STATE OF WASHINGTON
DEPARTMENT OF ECOLOGY

July 29, 2016

Re: CU-15-00007

Thank you for the opportunity to comment during the optional determination of nonsignificance process for a school on approximately 26 acres, proposed by Chimpanzee Sanctuary Northwest. We have reviewed the documents and have the following comments.

SITE PLAN

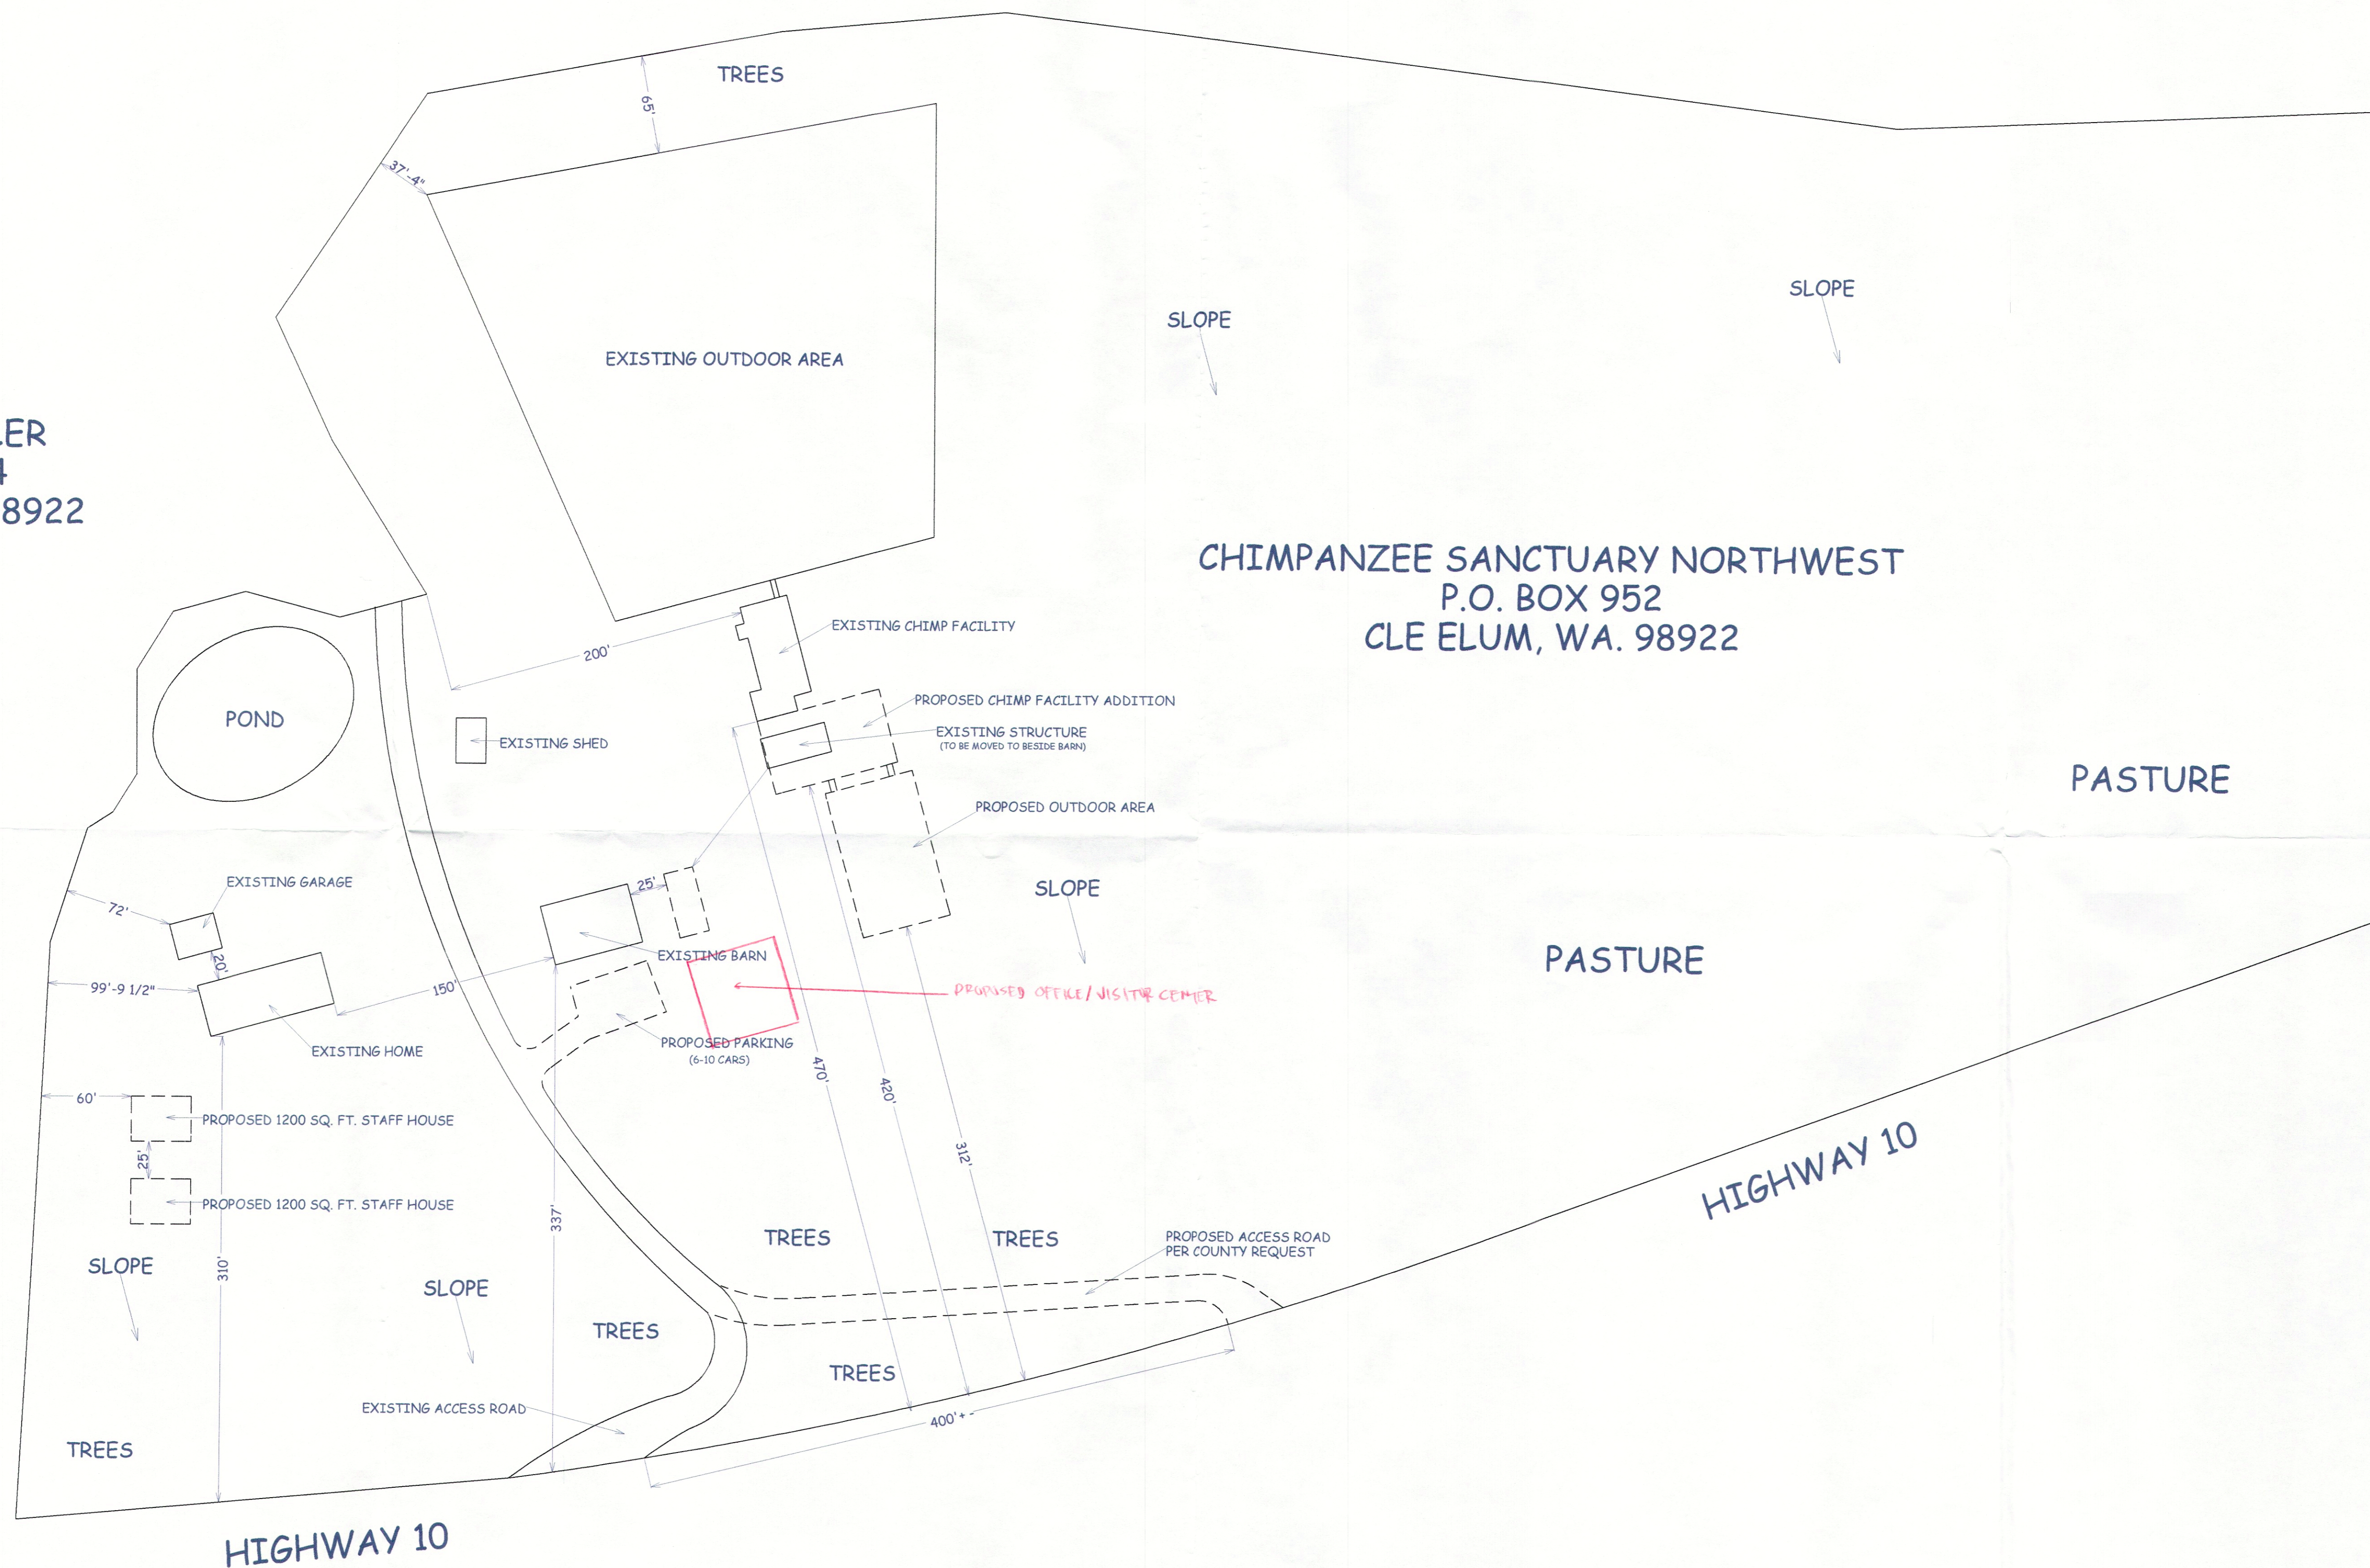
The wetland area as shown on the NWI map probably extends farther to the northwest. It appears that the proposed new road approach may intersect potential wetland areas or their buffers, or may intercept shallow groundwater that contributes to the hydrology of potential wetland areas below the proposed road. If that is the case, a wetland delineation and wetland mitigation report would be required to comply with the County critical areas ordinance and Washington State wetland protection statutes.

Ecology would be happy to assist the applicant/County with a site wetland reconnaissance to determine whether a wetland delineation report and or wetland mitigation is needed. Please call **Catherine Reed** at (509) 575-2616 for wetland assistance.
